Report of the Head of Development Management and Building Control

Address: 14 WILLOW TREE LANE HAYES

Development: Change of use from a 6-person House in Multiple Occupation (Class C4) to a 7-person House in Multiple Occupation (Sui Generis) (Application for a Certificate of Lawful Development for a Proposed Use).

LBH Ref Nos: 5516/APP/2025/3218

HD00257 - PL03

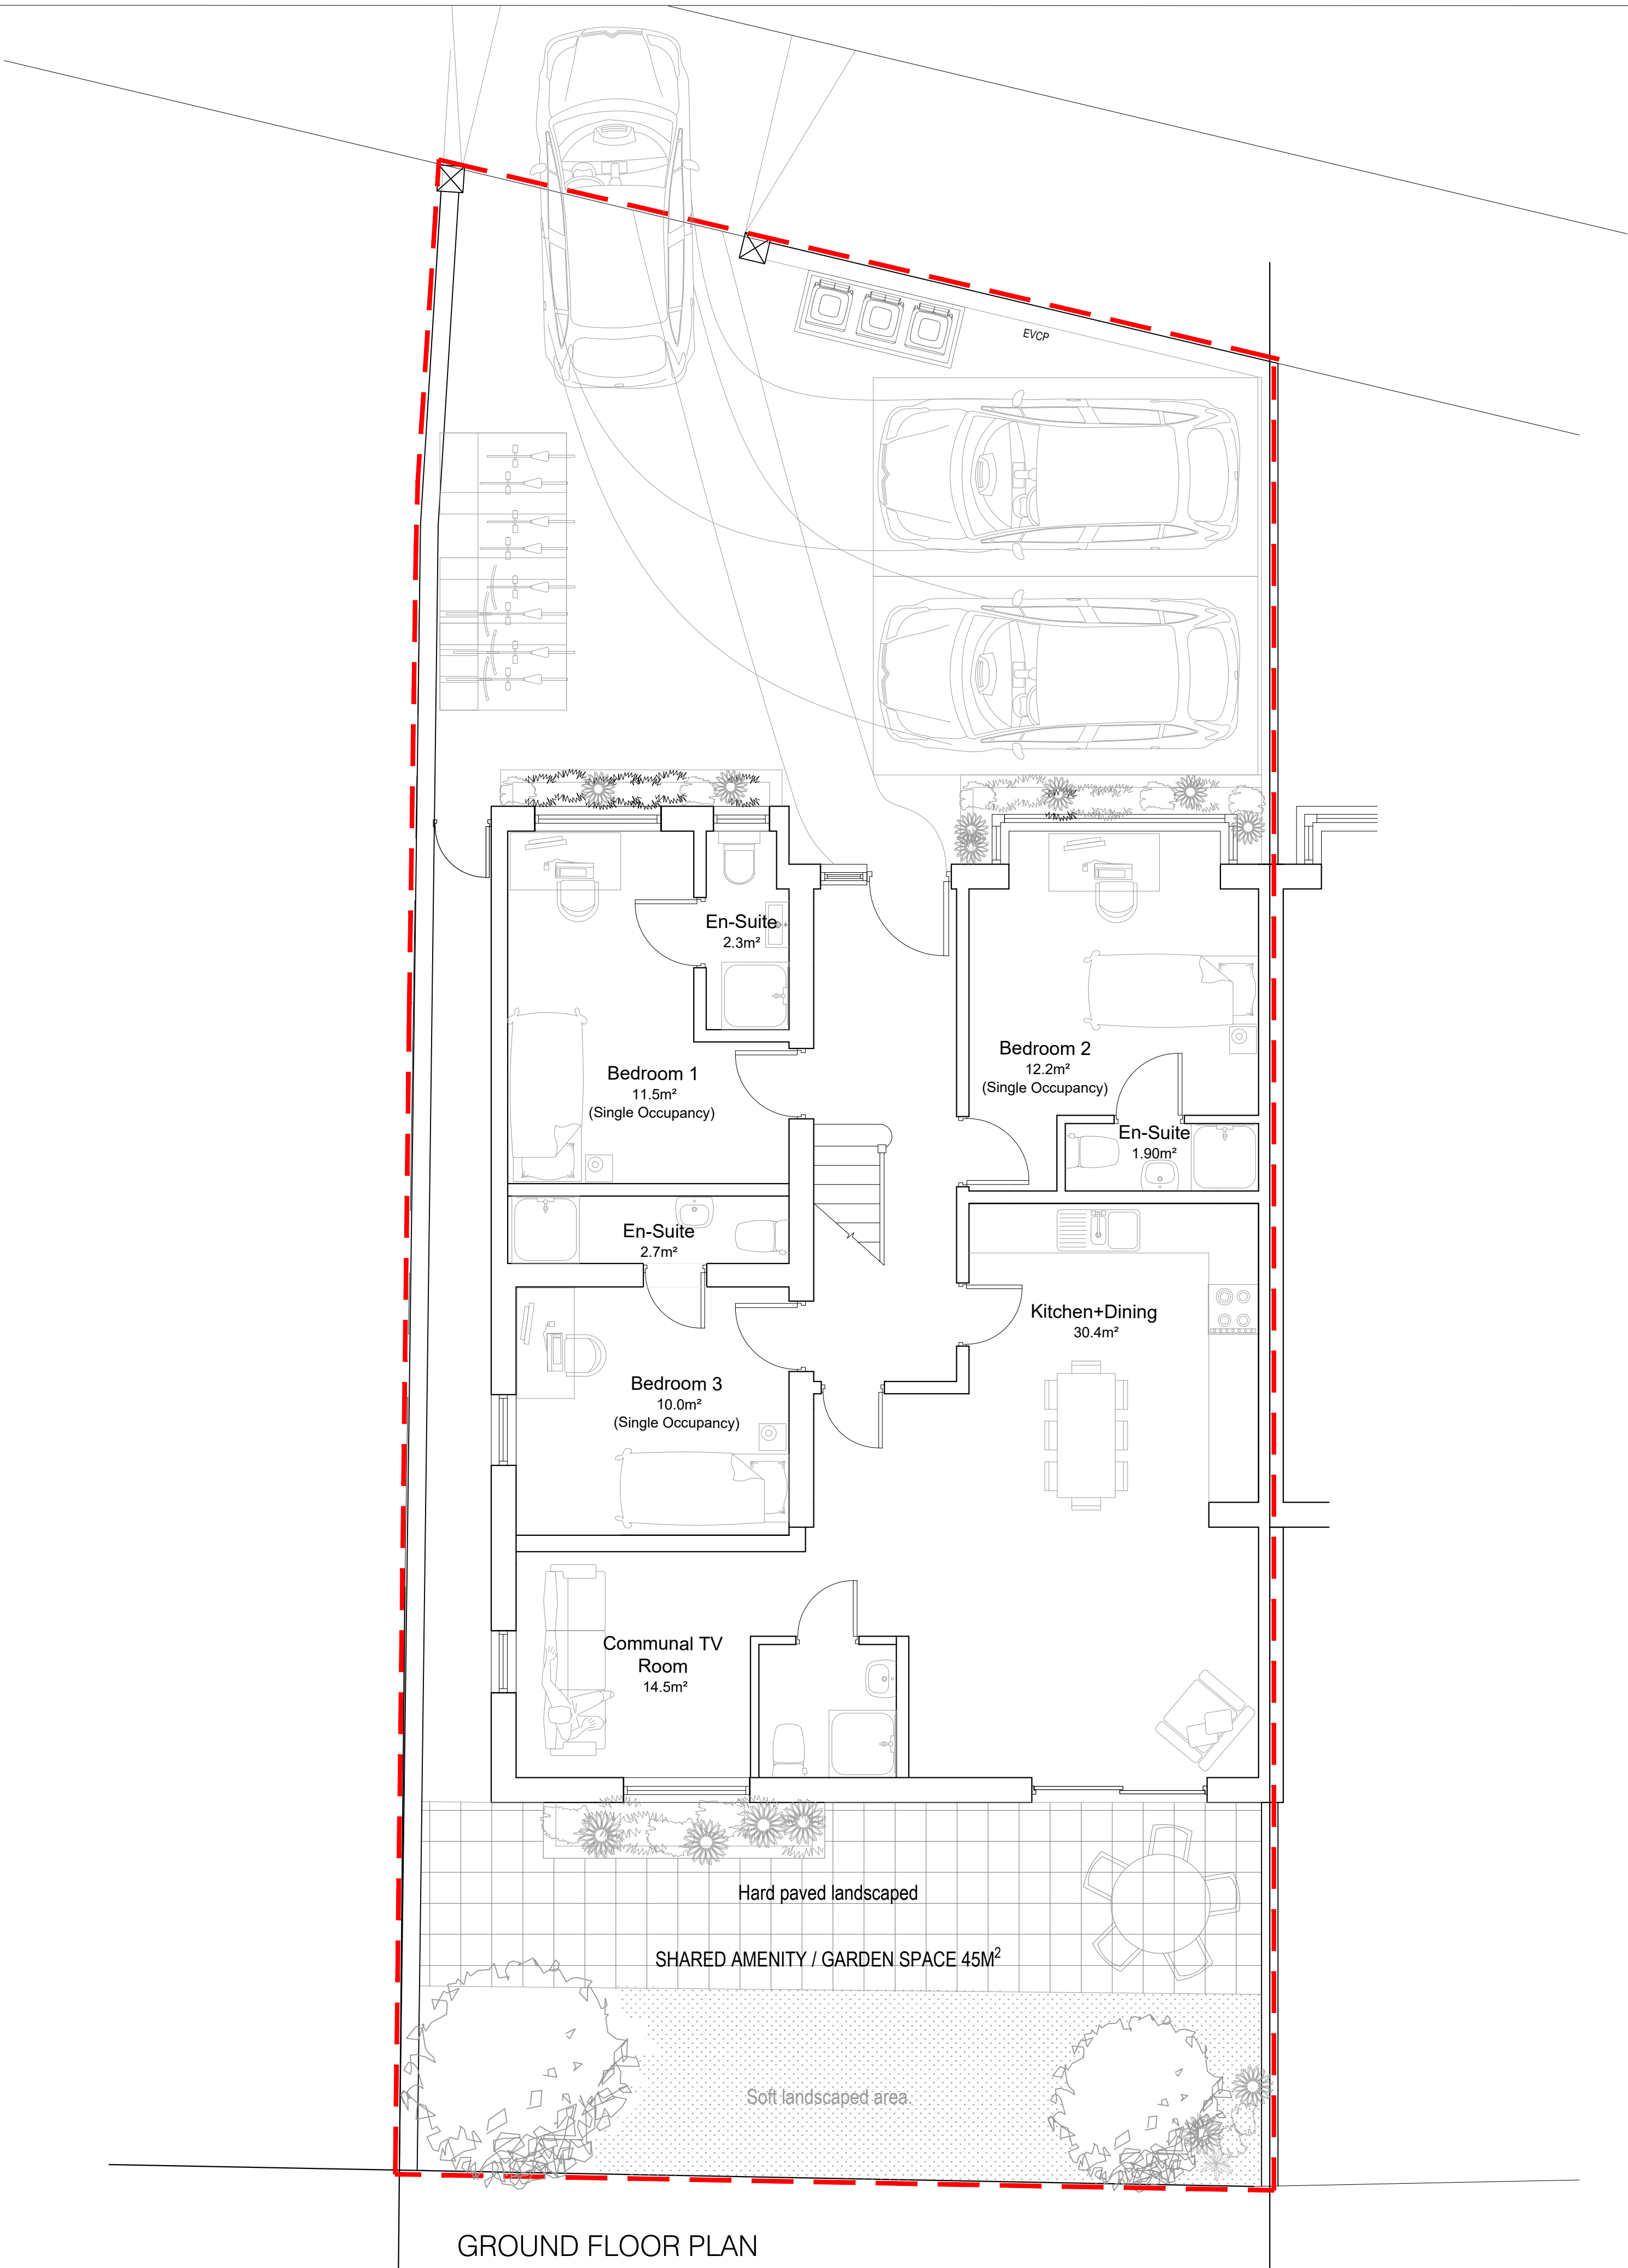
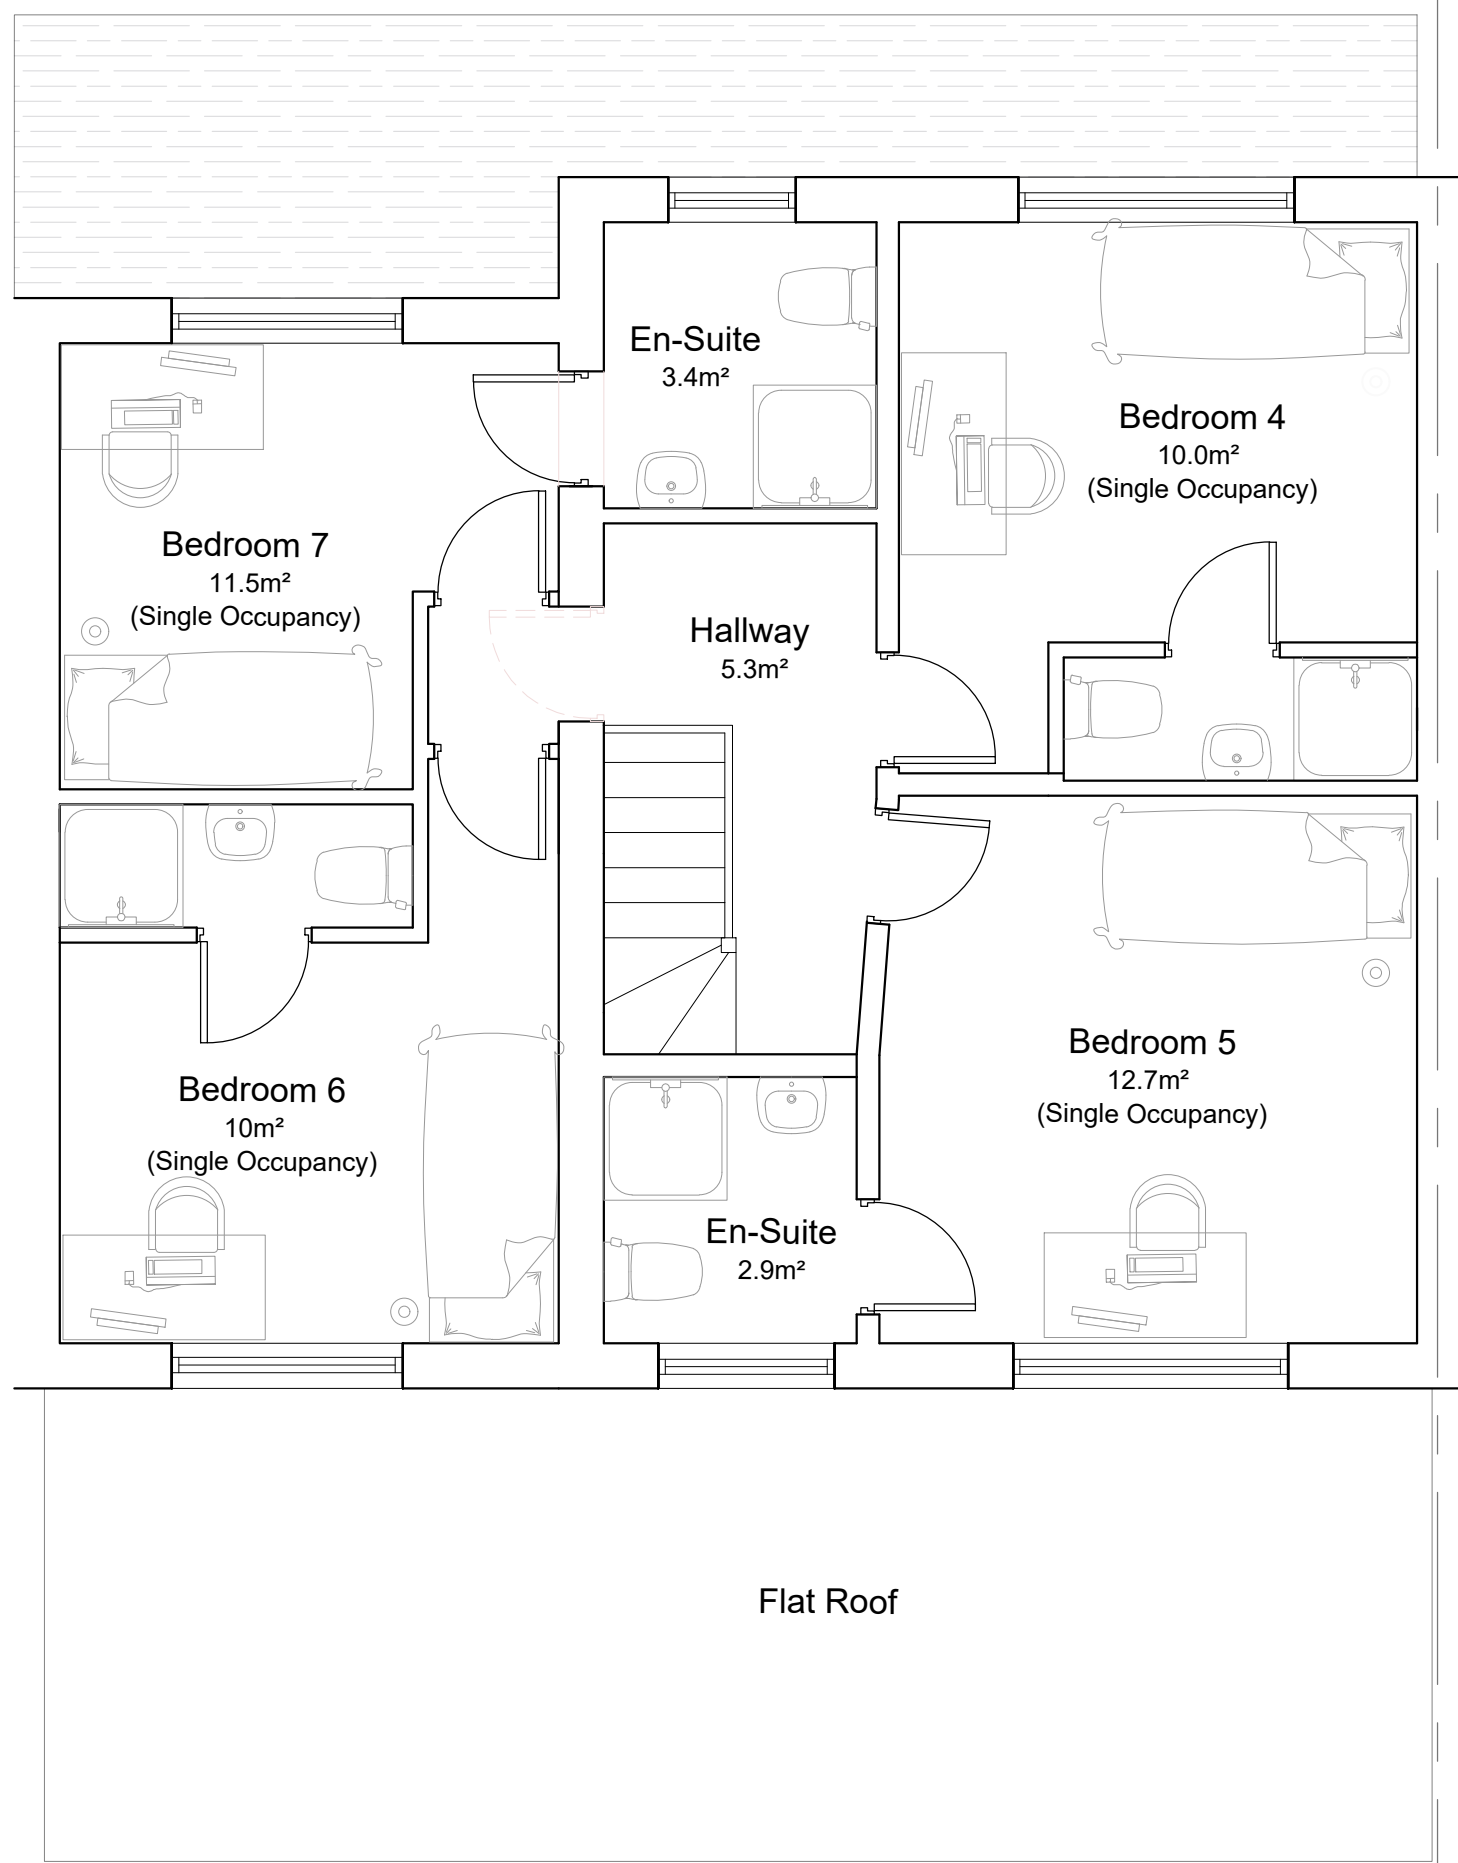
The submitted plans indicate the proposed use of the storage room and utility room as a 7th single occupancy bedroom with en-suite bathroom. The proposed bedroom measures 11.5m² with an en-suite bathroom (3.4m²).

Officers note the discrepancy with the submitted planning statement which states:

"The property has lawful use following the aforementioned certificate and is being used as a 6-person HMO (C4). This proposal is to use two of the bedrooms to provide double occupancy and therefore there is no physical internal or external development involved."

Officers confirm that the application is assessed on the submitted plans and description of development.
